WEST SUSSEX COUNTY COUNCIL
STRATEGIC PLANNING CONSULTATION

SUBJECT: Y/22/17/PL - 1 No. dwelling.

Land rear of 2,4 & 6, Gladstone Road, Mill View Road, Yapton, West Sussex, BN18 0JP

Site Plan

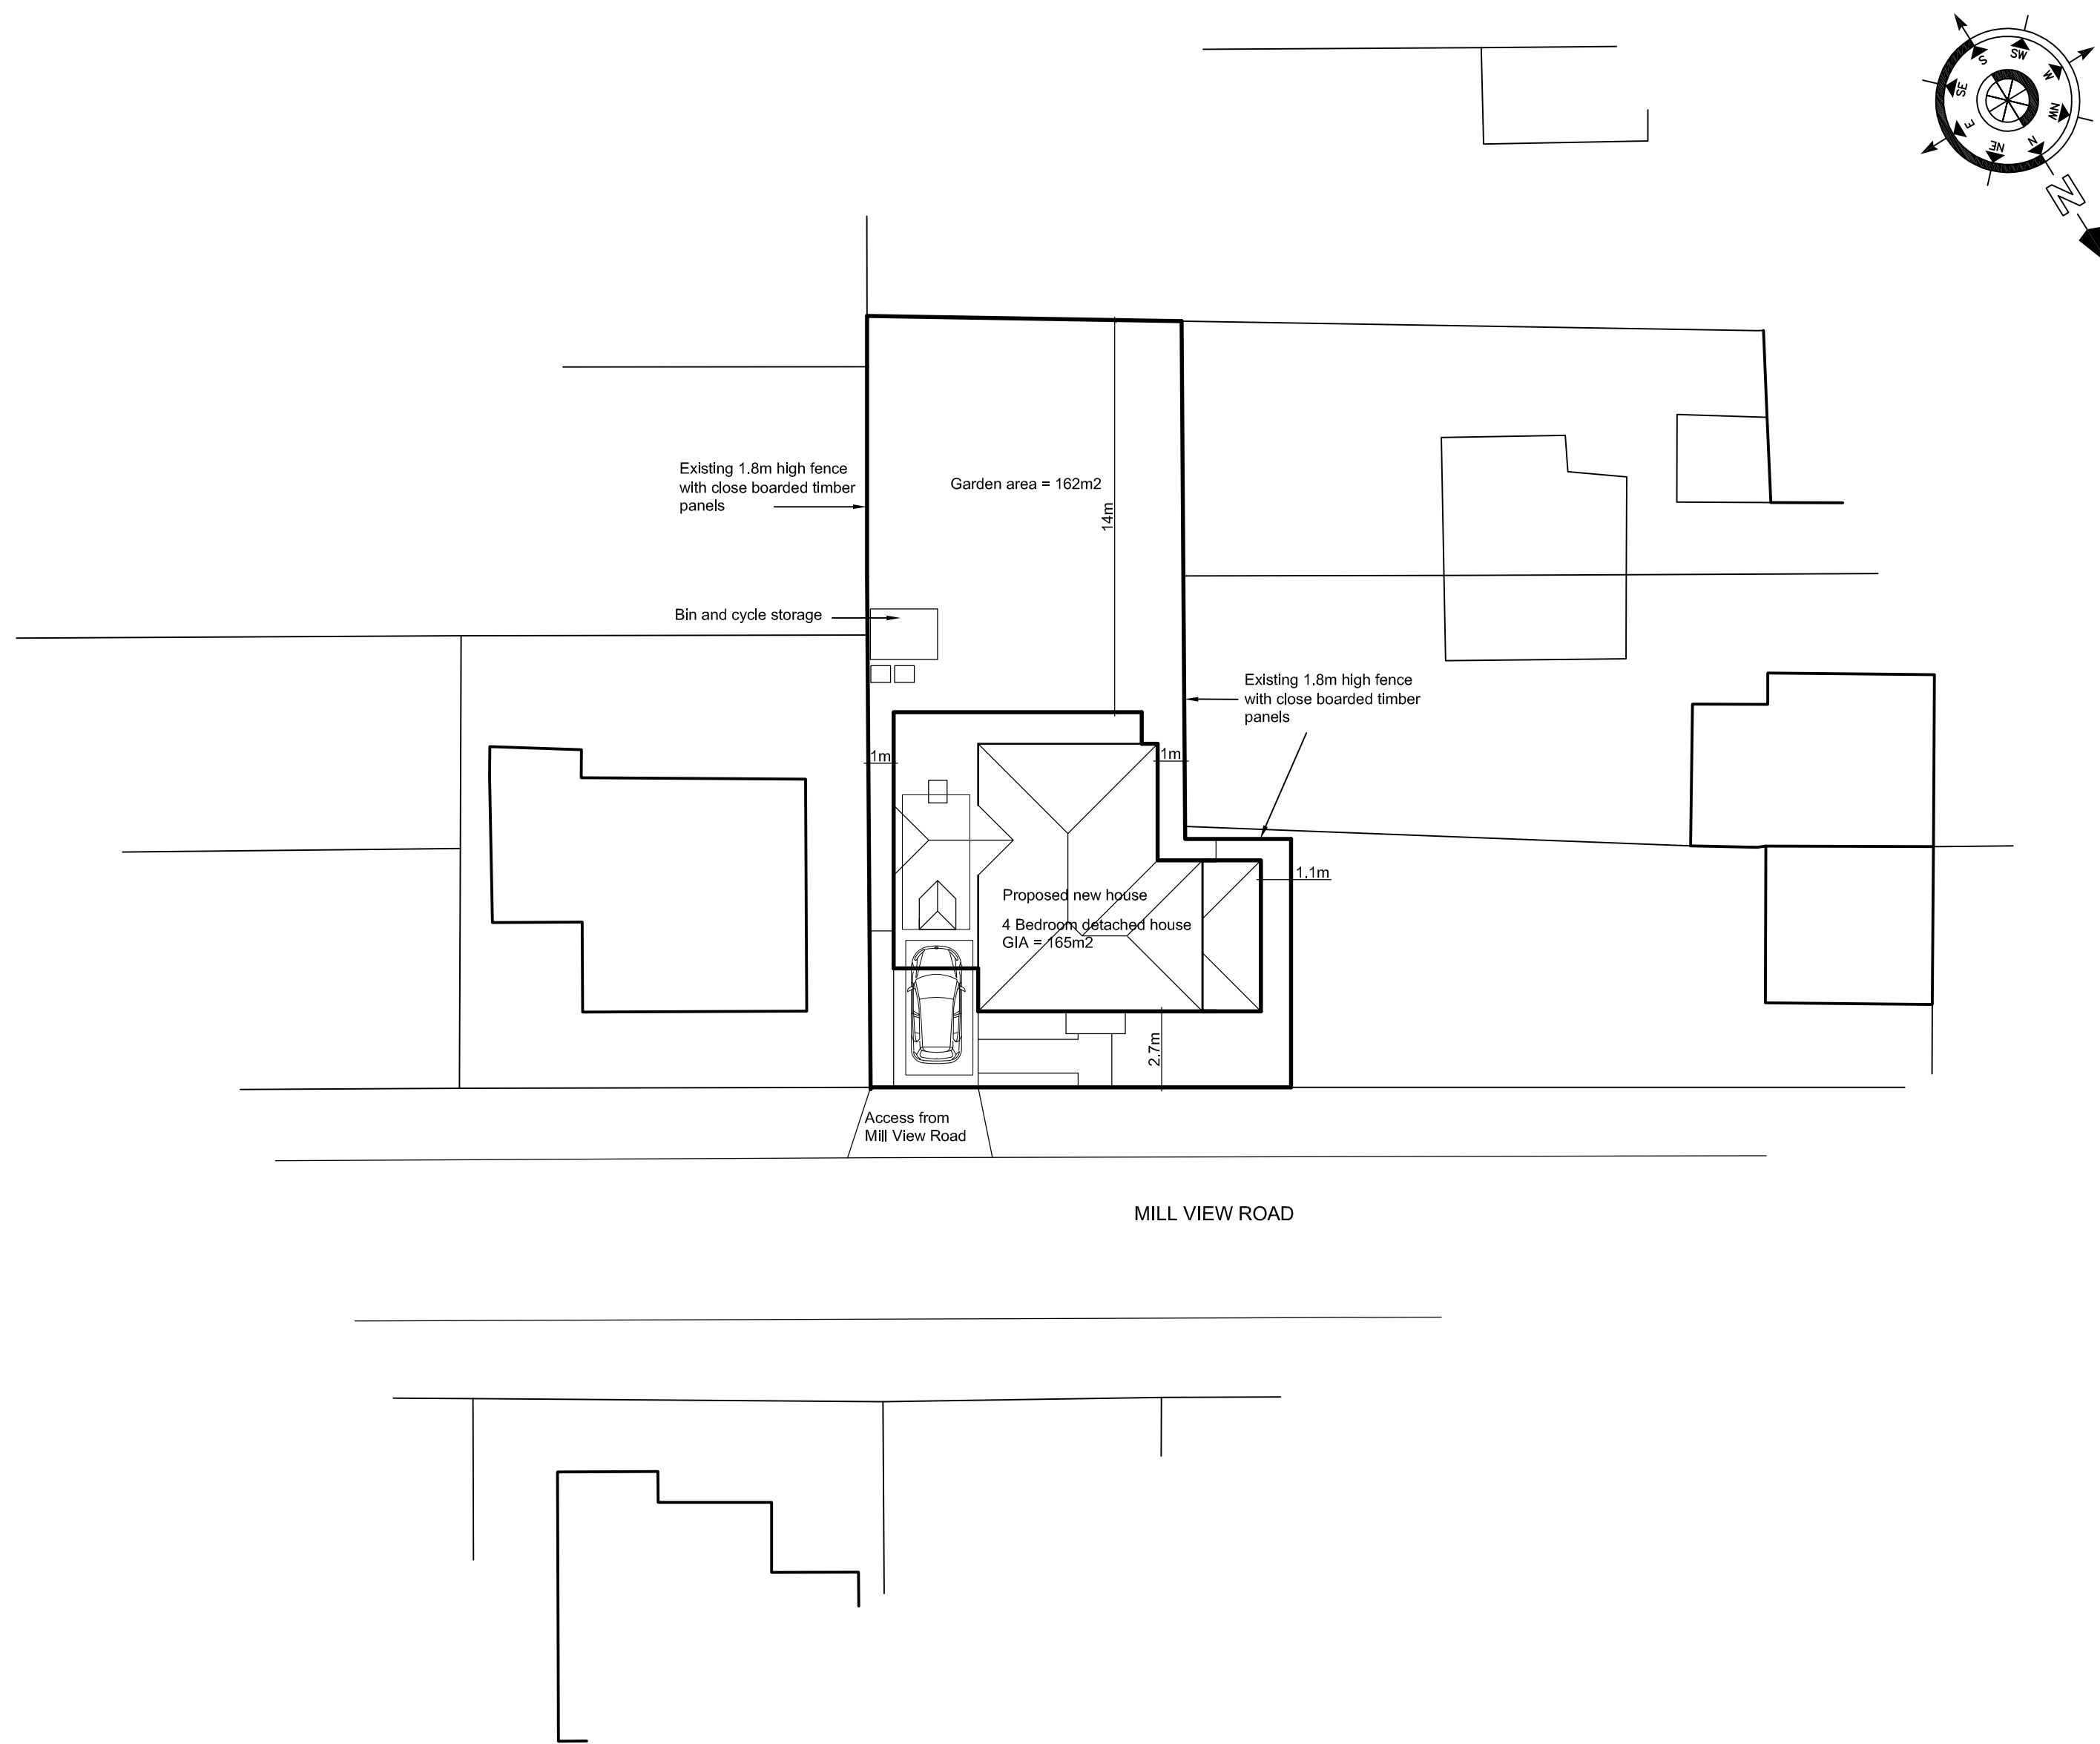
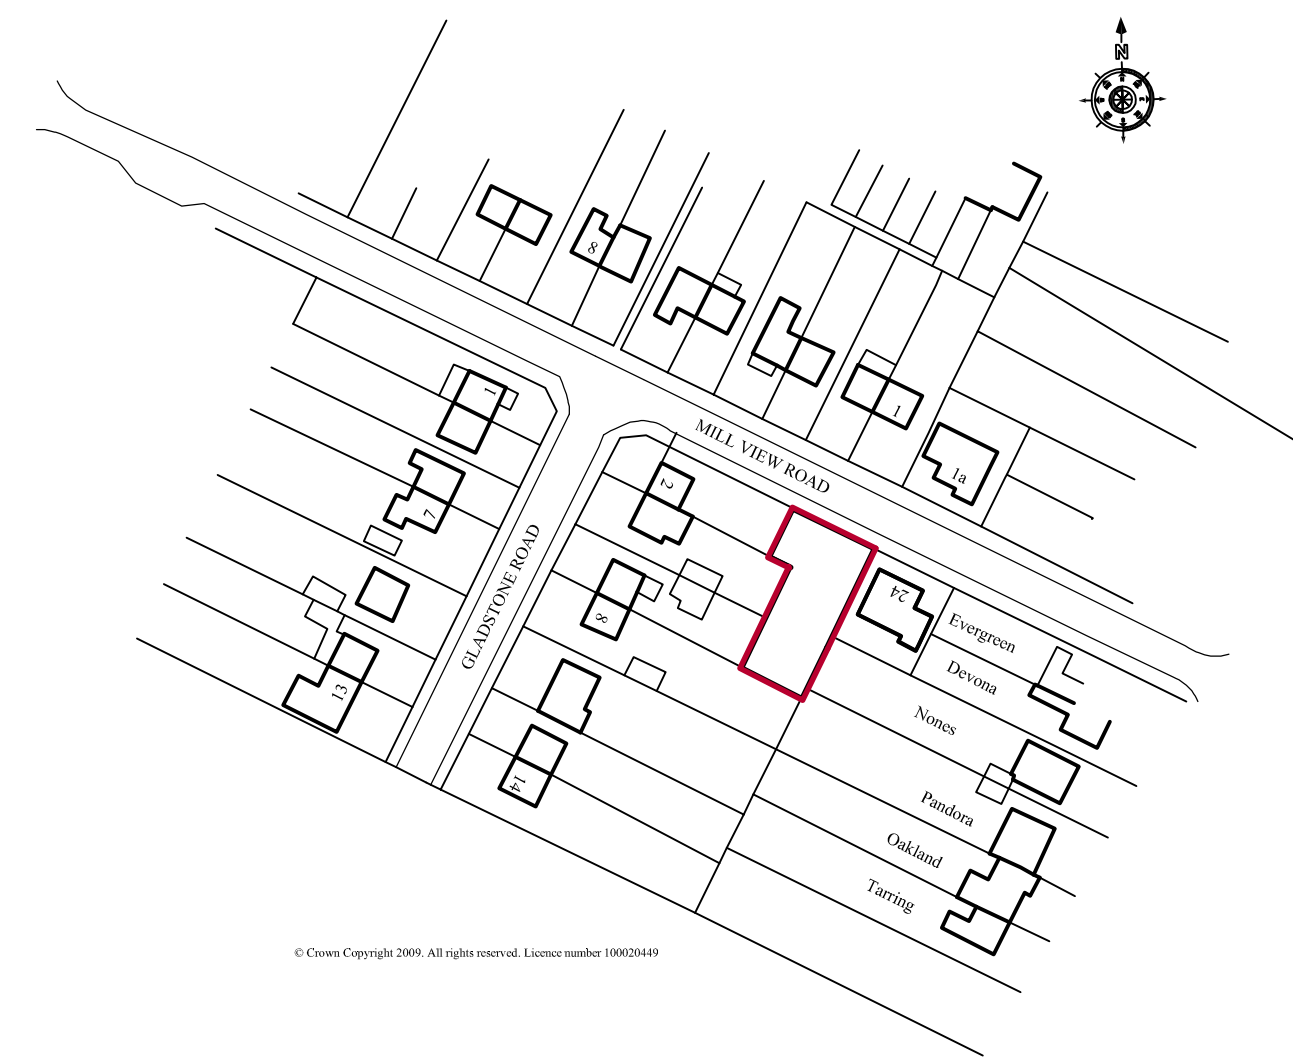
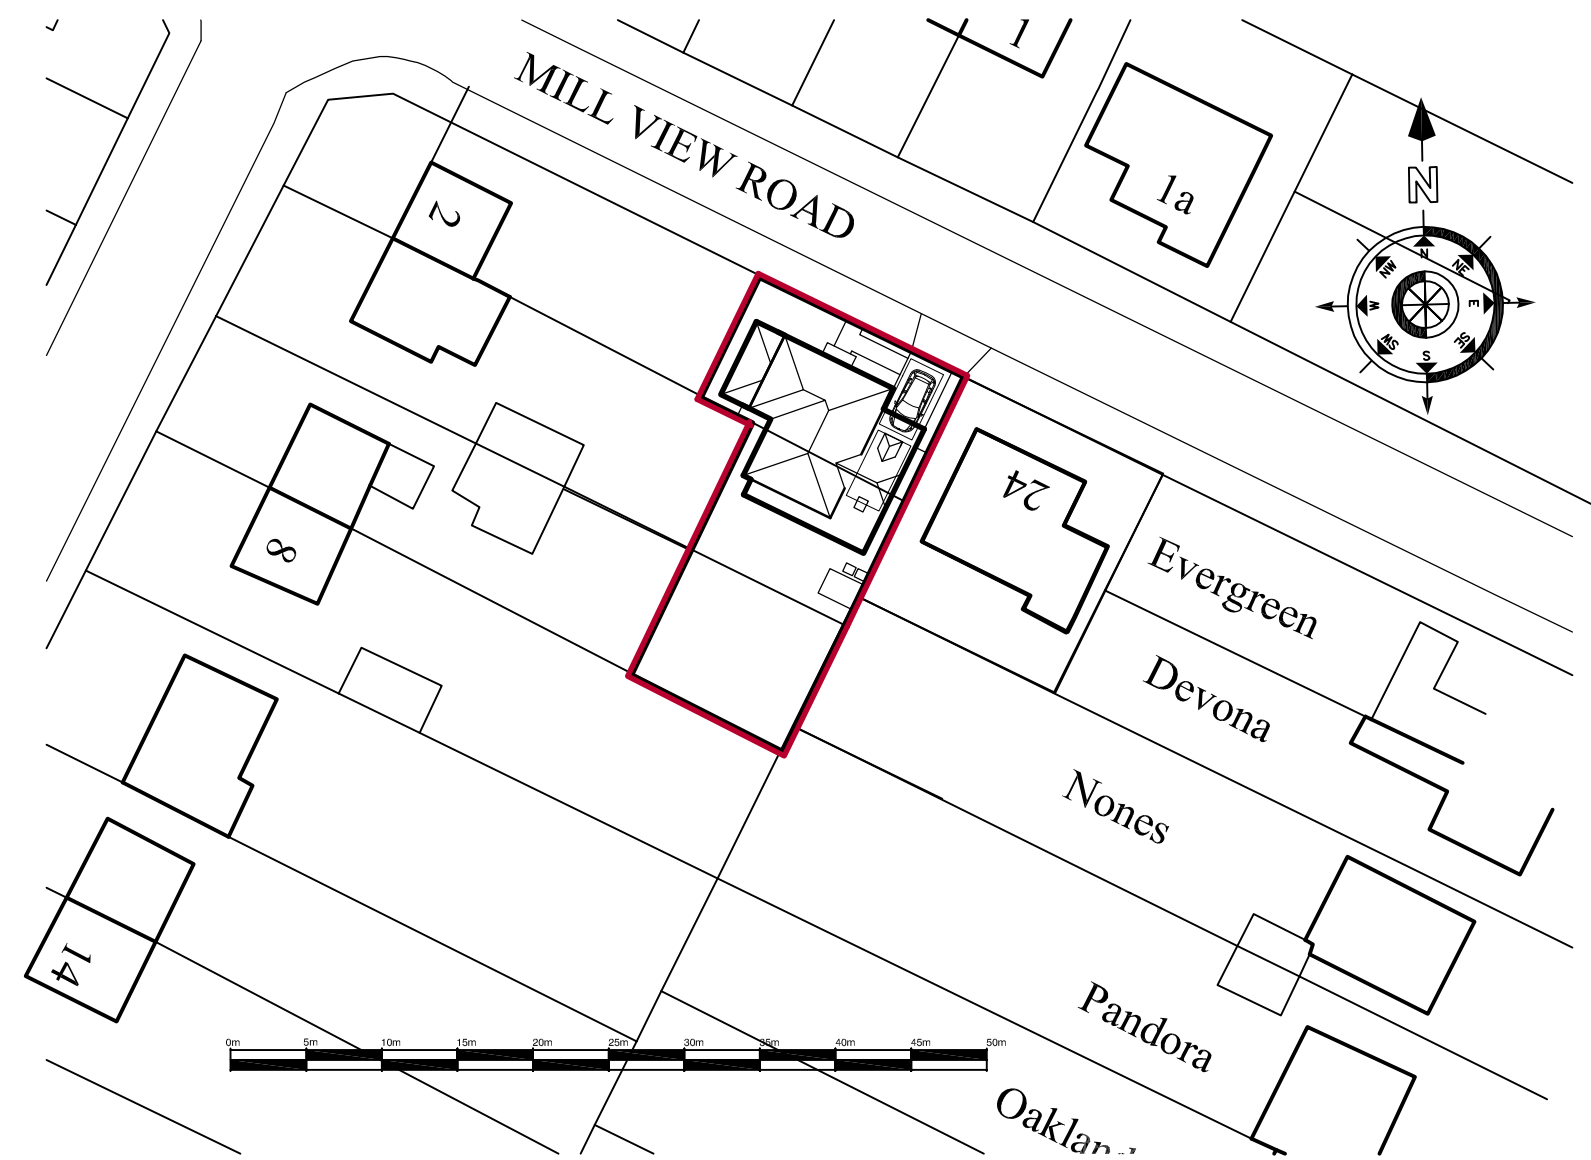
From inspection of the plans and local mapping, there appears to be no apparent visibility issue at the point of access onto Mill View Road. Visibility splays suitable to the posted speed limit (43 metre as per advice set out in Manual for Streets) is achievable entirely within the maintainable highway.

The VCO must be constructed to a specification agreed with the local area engineer and a licence obtained for these works on to the public highway. The hardstanding should be constructed of a hard bound material to prevent gravel overspill on to the public highway.

A turn on site would be preferred, clearly though there is insufficient space to achieve this. However other properties have similar arrangements and balanced against this is the benefit of providing an opportunity to remove a vehicle that would otherwise be parked on the highway in a location where the existing practice is on-street parking by residents of adjoining properties which results in a noticeable narrowing of the existing available carriageway space.

REVISION			
CLIENT		Mr M Hopkins	
PROJECT		Proposed new house at Mill View Road, Yapton	
DRAWING		Proposed Plans and Elevations	
SCALE 1:100	DATE mar 2017	DRAWING No	Rev
DRAWN	CHECKED	10 / 75 / 100

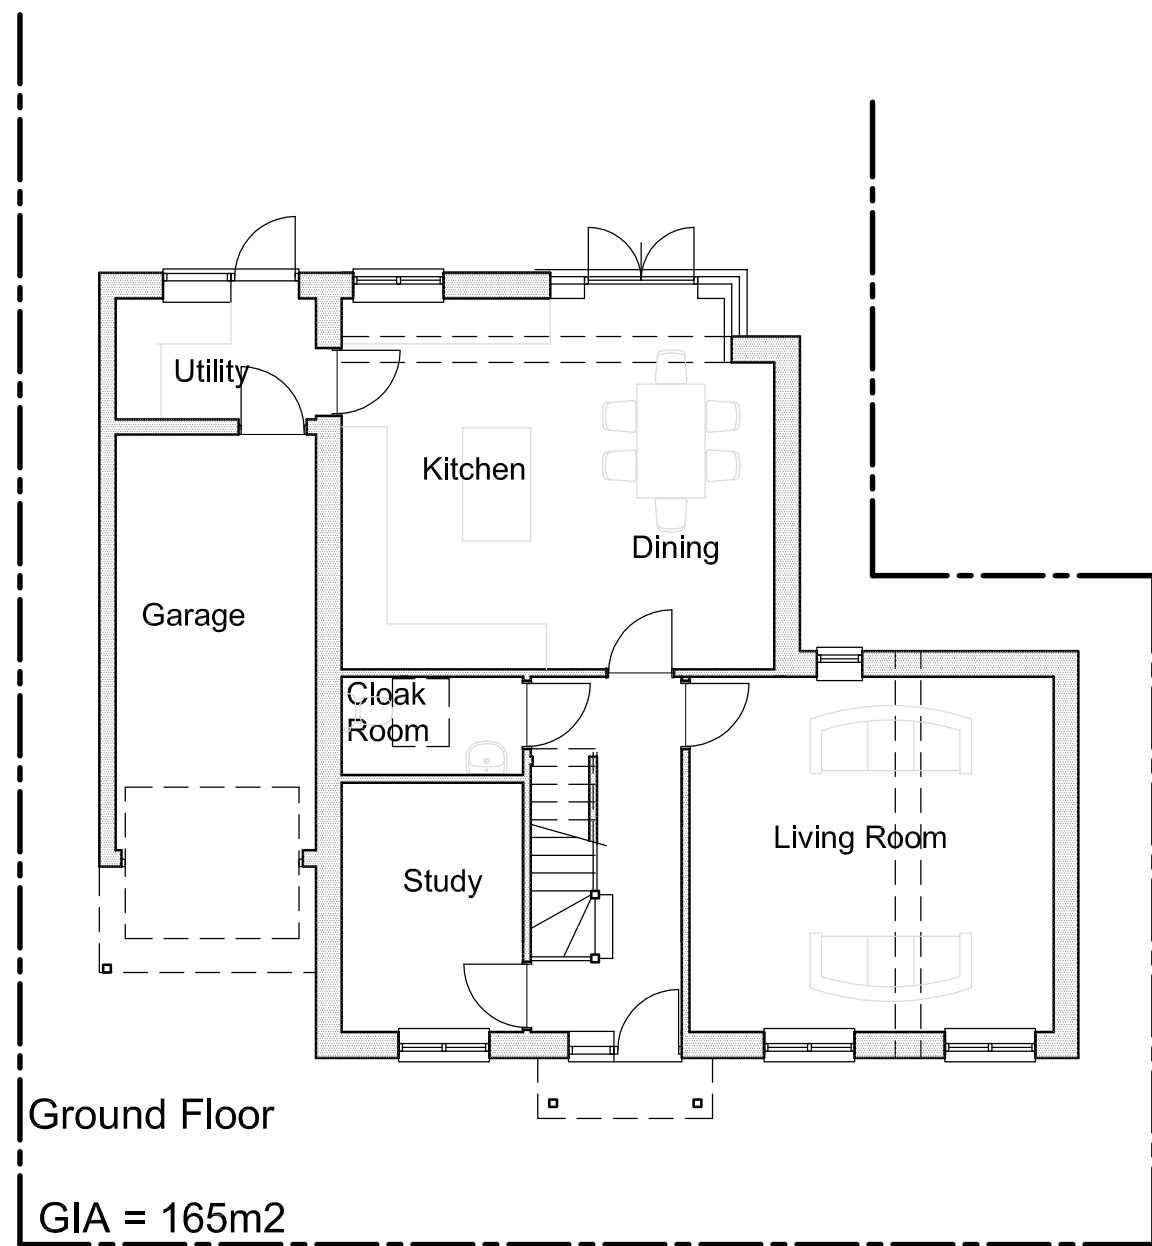
The integral garage is insufficient dimensions to be counted toward parking provision; we would advise that this be enlarged to 3m by 6m to accommodate a single car. Nevertheless, if the applicant does not wish to do this one space is still to be provided off street fronting the garage that can be counted as allocated parking provision. On this basis WSCC guidance recommends that two off street parking spaces be provided. Local mapping shows that occasional on-street parking occurs in the vicinity with no evidence of highway safety concern. We could therefore not object to the proposed level of parking provision from a highway safety or capacity point of view.
